**Proposed new dwelling on land between 48 and 50 The Ridgeway, Cuffley,
Hertfordshire EN6 4BA**

Welwyn Hatfield Borough Council reference 6/2022/1943/FULL

**Response to comment letter of 6 September 2022 by Hertfordshire CC
Development Management Group concerning highway matters.**

Title Vehicle access and visibility splay

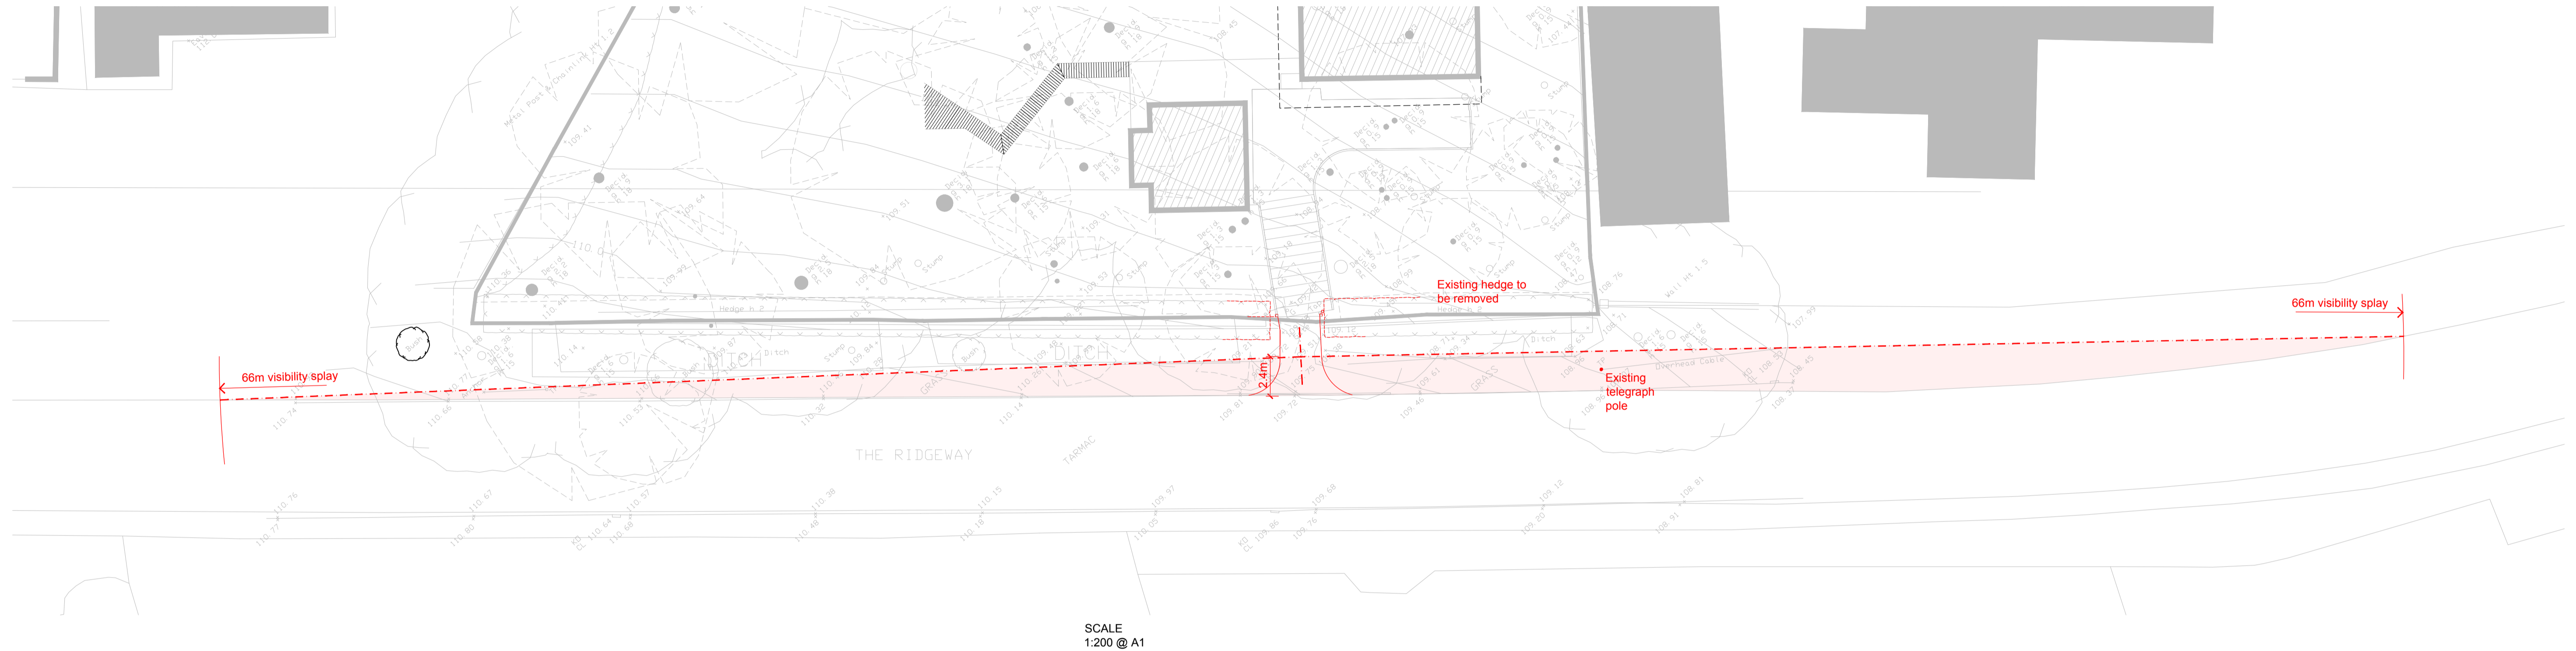
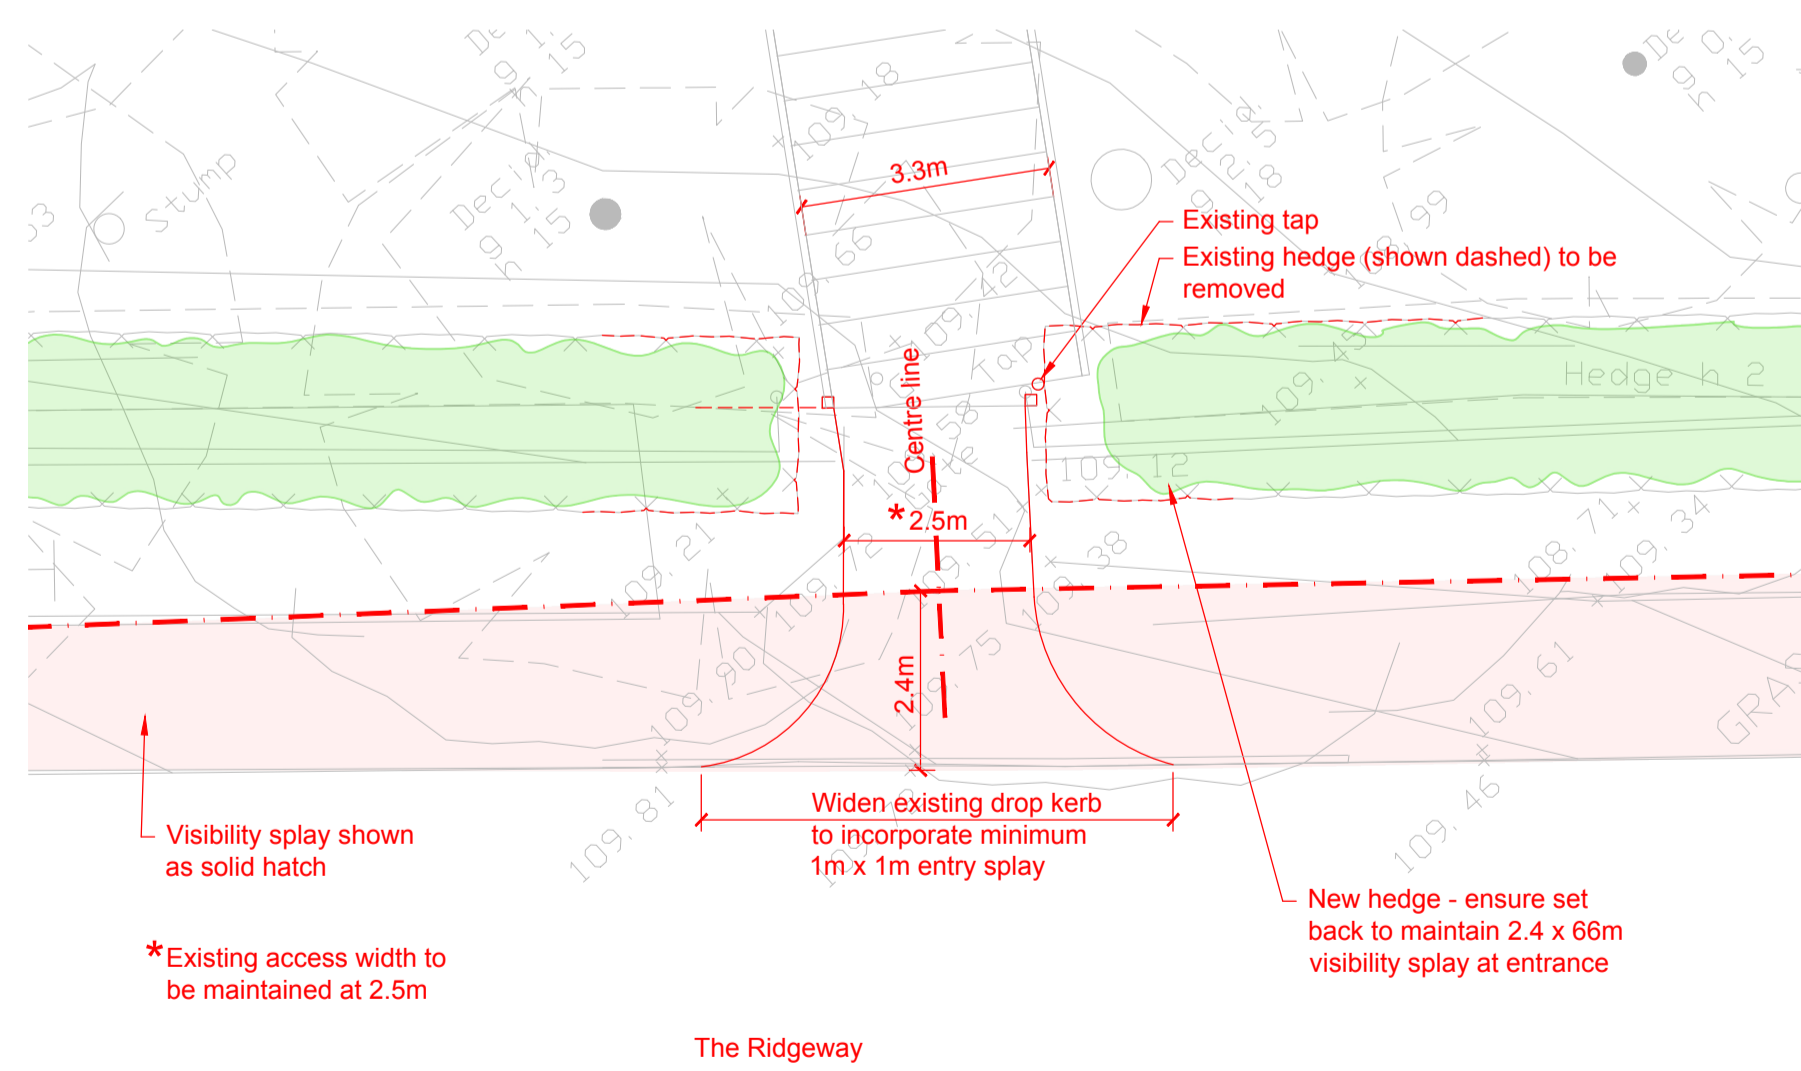
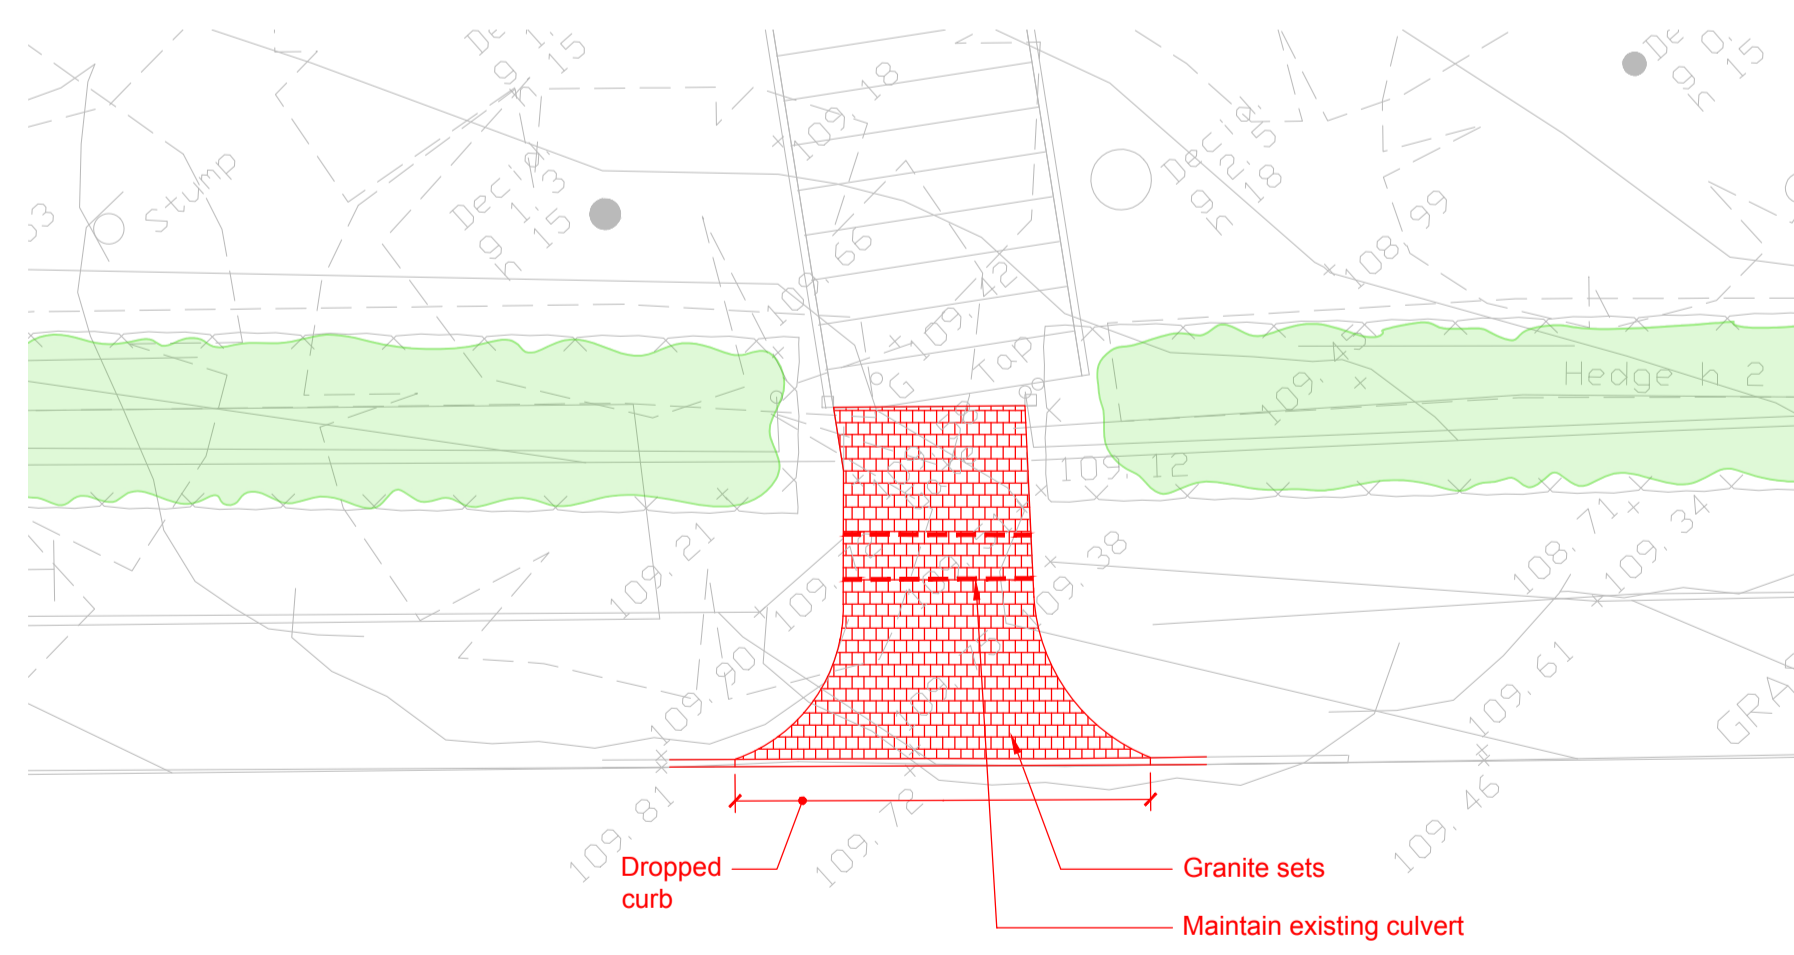
The first issue raised was clarity over the design of the vehicle access and how it will cross the ditch. In designing the scheme the architect had considered that the existing access would have to be widened to 3.1metres to allow Fire Brigade access, that has now been revisited and it is evident that no widening of the access will actually be required for that purpose. The drawing now submitted shows the existing access drive, which passes over a concrete culvert, retained at 2.5metres as it is currently. That access has been proved adequate for HGV access to the site for management purposes.

The second issue was a request that 2.4m by 66m stopping sight distance visibility splays be demonstrated and these have been checked and are shown on the attached plan. The frontage hedge of the site is about 5m from the carriageway edge and there will be no difficulty maintaining vision across the site frontage; beyond the site boundary any overhanging vegetation cannot be controlled by the applicant but can be controlled by the highway authority requiring that it is cut back.

I trust this satisfactorily addresses the two points of concern to the highway authority and would ask for the attached drawing to be added to the application plans already submitted.
